Our Ref: R/36/20/HH
Your Ref:

Town & Country Planning Act 1990 (as amended)
Town & Country Planning (Development Management Procedure) (England) Order 2015
Application for Planning Permission for Works or Extension to a Dwelling

Development Single storey rear extension
Location 1 Staffords Close Rustington

BLOCK PLAN
Scale 1:500

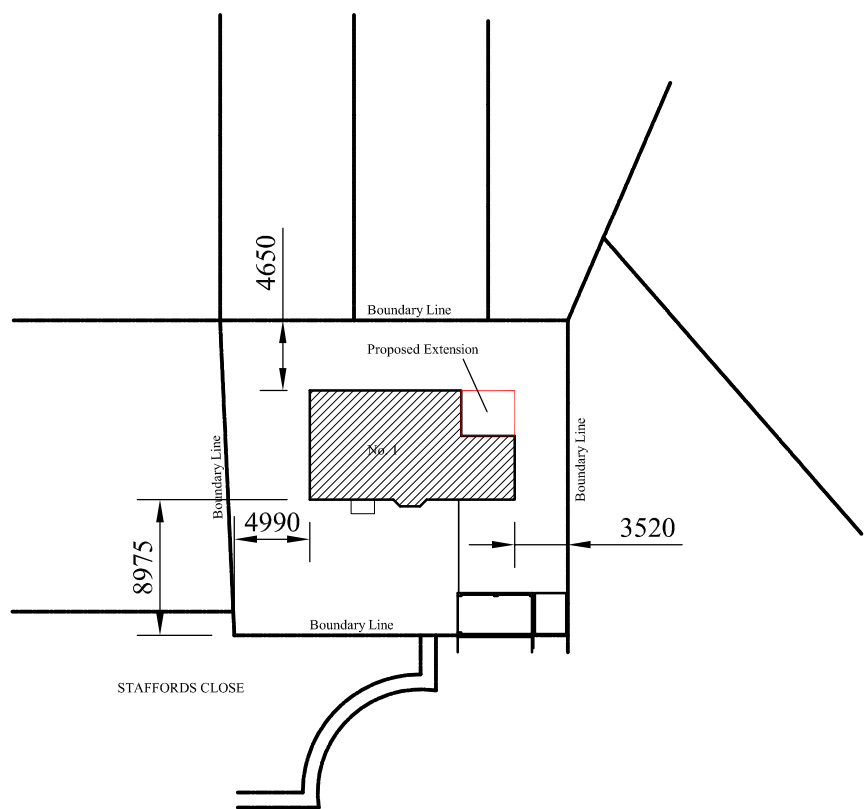
Block Plan: You are required to include dimensions from the proposed extension to all site boundaries on the block plan. Please amend.
